# CITY OF ALBUQUERQUE

October 26, 2017

RE: **5400 Sevilla NW**  
**Grading Plan**  
**Engineer's Stamp Date: 10/23/17**  
**Drainage File: F11D010A**

ENGINEER'S SEAL	VISTAS DE LA LUZ COMMERCIAL	DRAWN BY WCWJ
		DATE 10-31-17
		21644-LAYOUT-1-06-17
11/21/17	 <div>Rio Grande Engineering 1606 CENTRAL AVENUE SE SUITE 201 ALBUQUERQUE, NM 87106 (505) 872-0999</div>	SHEET #
DAVID SOULE P.E. #14522		JOB # 21644

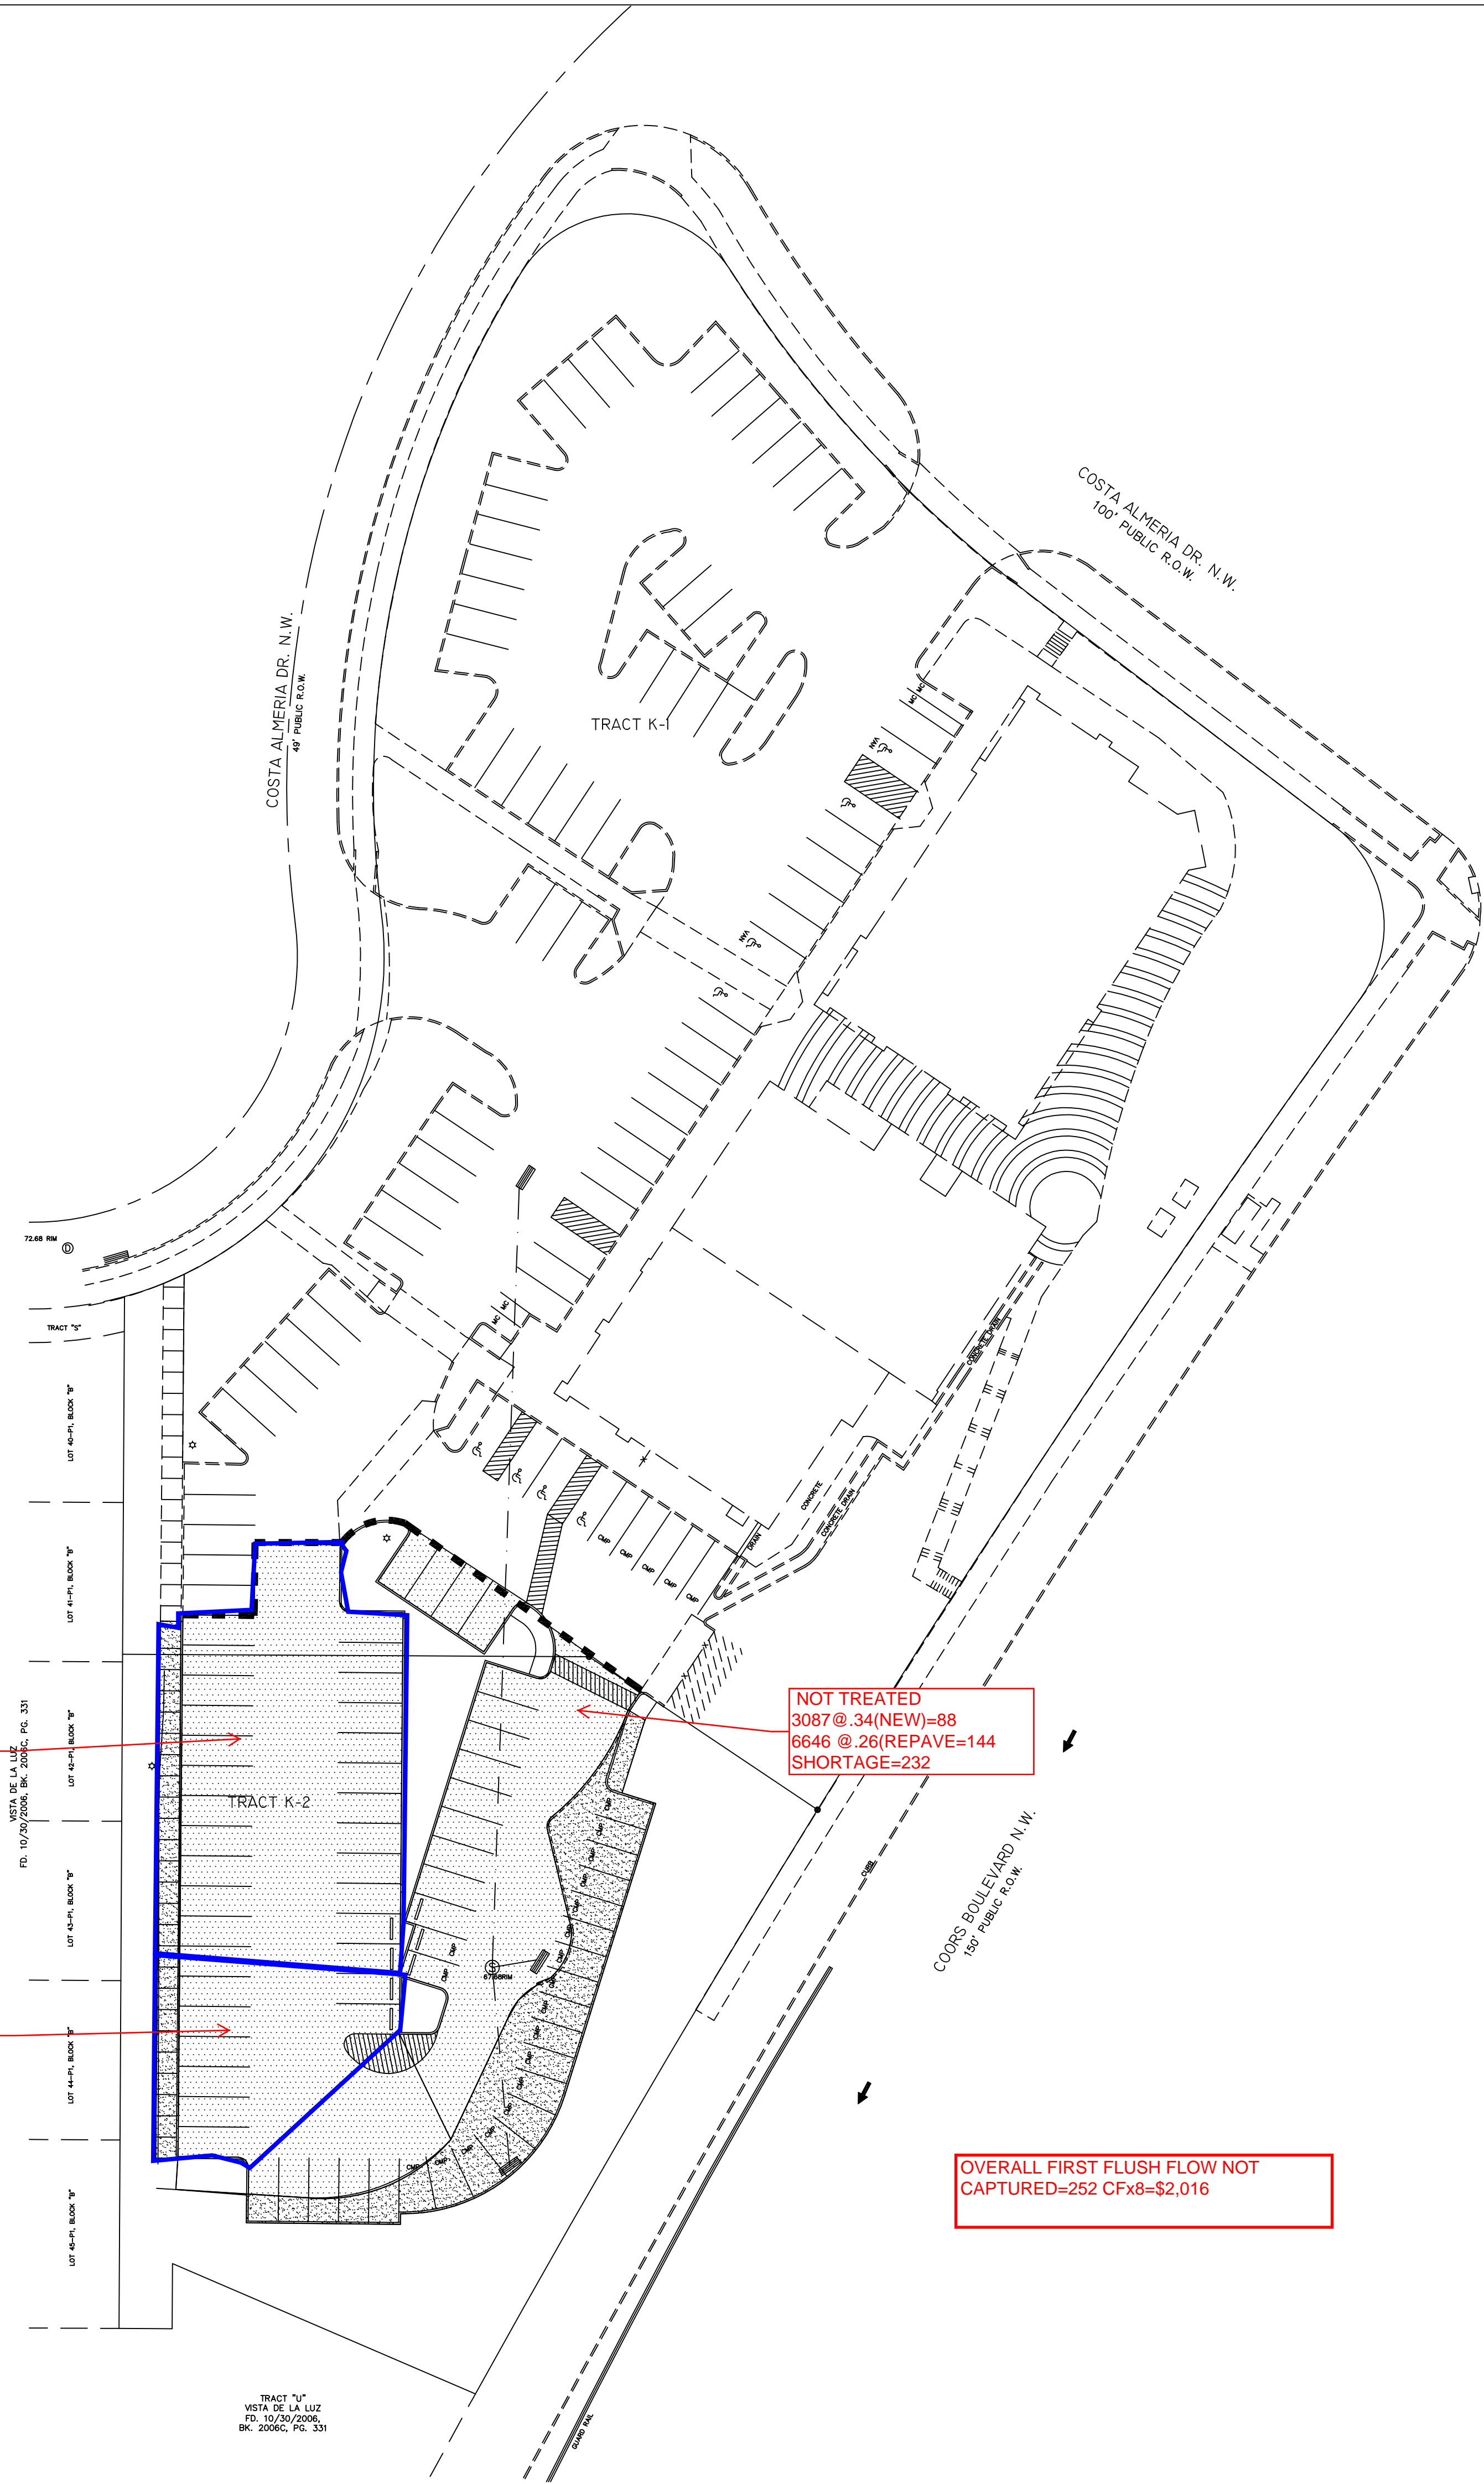
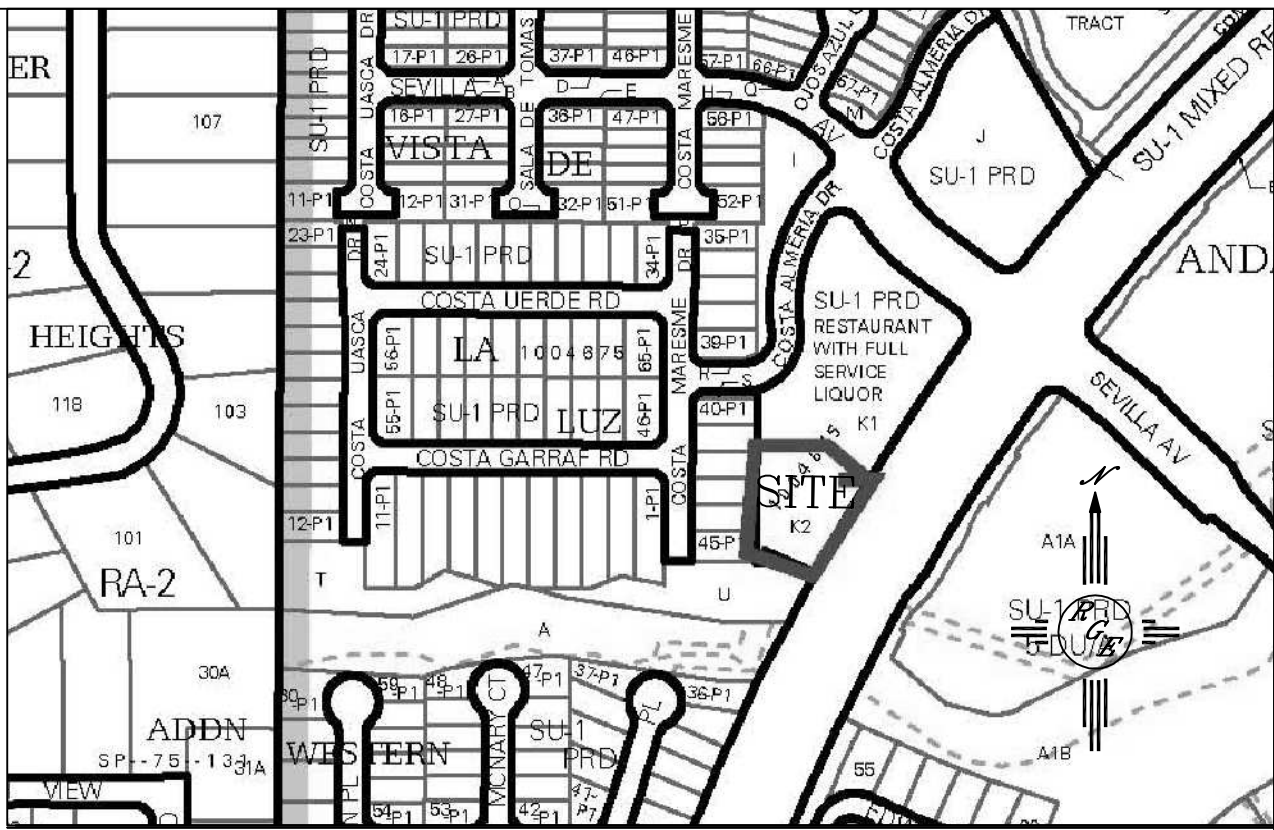
1. Clearly define and quantify the areas of new paving vs. re-paving. If the repaving is actually mill and overlay state so.
2. Quantify the first flush requirement based on the newly paved and repaved area.
3. A drainage basin exhibit is required. This will need to show which areas drain to which ponds.
4. The ponds need to be located where they can effectively capture the first flush requirement from impervious surfaces of the lot.
5. If the first flush volume cannot be captured on-site, the bypass volume must be quantified for payment of Fee-in-Lieu.
